MB TOWN PLANNING

Thomas Street Carpark
CHATSWOOD NSW

Proposed Section 75W Modification 6 to approved Major Project
09_0066

Objection in response to notification

BUILDING 1
ELEVATION - EAST
A-0123
SECTION 75 W SUBMISSION

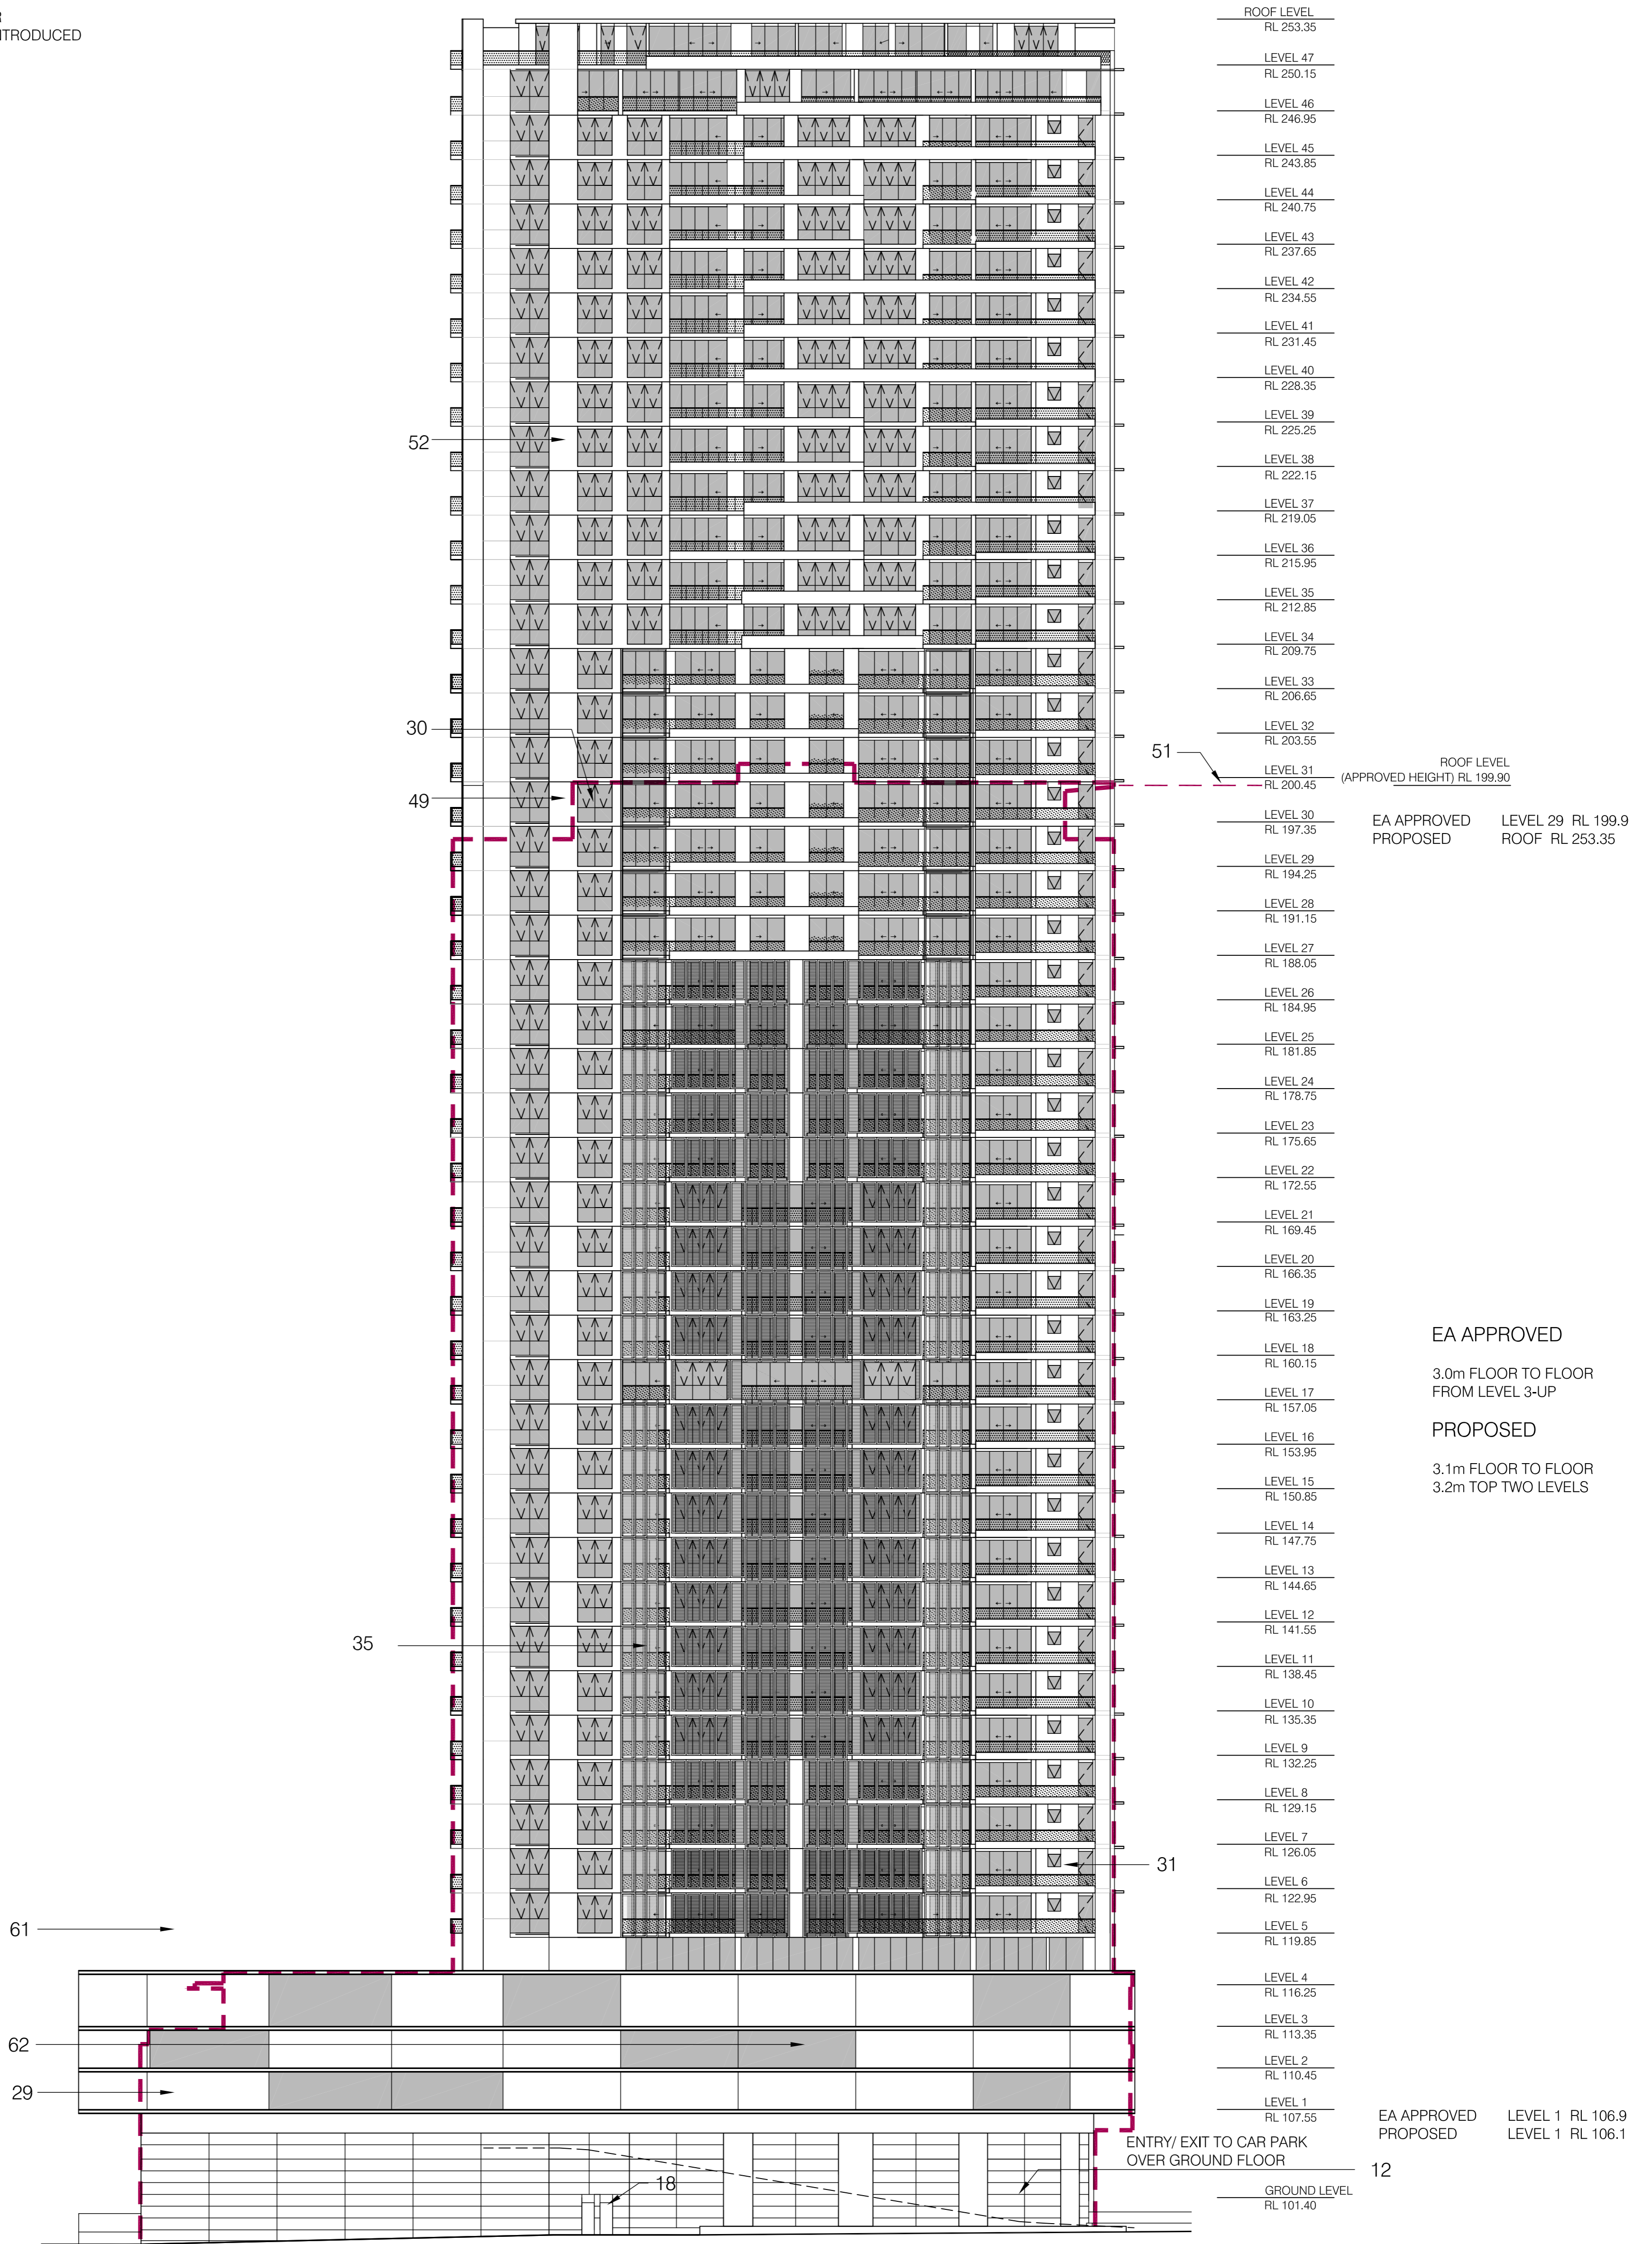
- ✦ The proposed above ground car-parking introduces a building form having a nil setback from the eastern side boundary of 17.0 metres in height. It is unclear from the submitted drawings whether there is also a nil setback element that is as high as 24.2 metres - see Figure 1 below. In comparison, approved Modification 3 includes an element on the eastern boundary for building 1, being a raised, cantilevered child care centre play area, with a nil setback to the southernmost three metres of the side boundary. ;

Proposed Modification 6 involves a car-parking structure having a nil setback for the entire western boundary of 12 Thomas Street and having a height of 17 metres. (The height may be even greater depending upon interpretation of the badly drawn northern elevation).

The submitted eastern elevation for Building 1 indicates openings to the wall on the eastern side of the proposed driveway ramp along the eastern property boundary. The submitted eastern elevation for Building 1 is of insufficient quality to provide certainty in relation to what is the proposed treatment of the eastern wall. For the purposes of this assessment, it is assumed that the wall is enclosed but if it is not, that would further expand the scope of concerns regarding acoustic impacts.

The Cross Site link

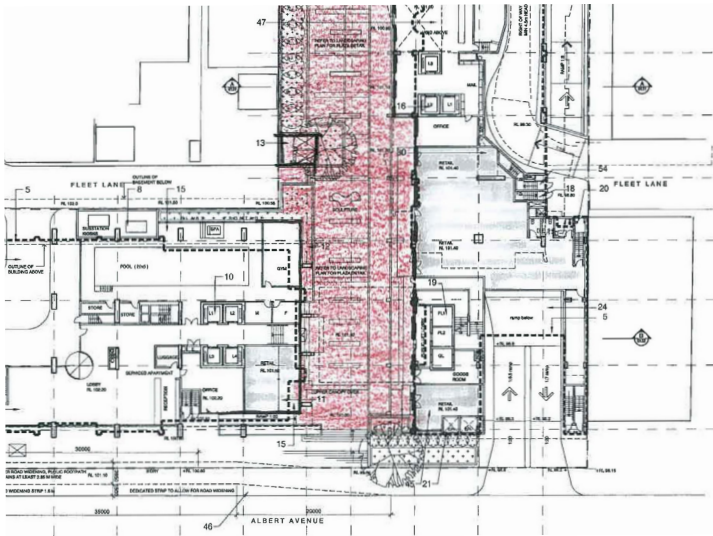
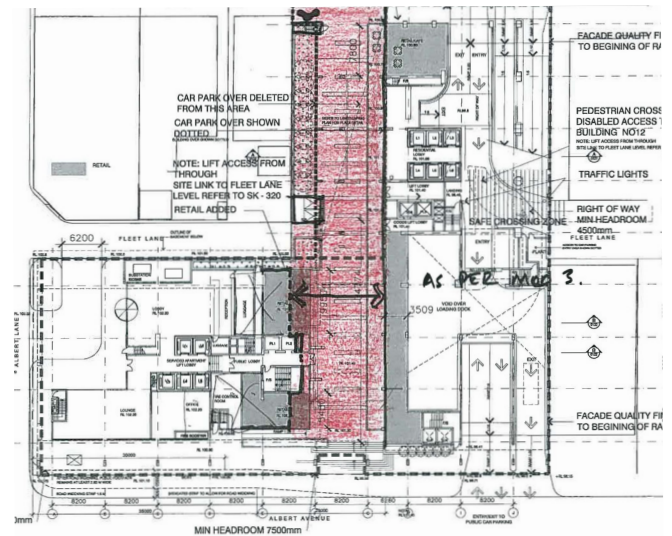
The proposed development replaces the open plaza space with a car-park wall with a plaza opening. The plaza becomes covered by the car-parking structure, with only a three metre lightwell to its western side. This reduces the quality of the space - people are attracted to open air spaces and there is a need for such spaces within densely built-up areas. The space becomes internalised to a greater extent and the perception arises that the space is private rather than public or semi-public.

The proposal represents a travesty of the original design intent and takes away a crucial element in the justification for the project as a whole.
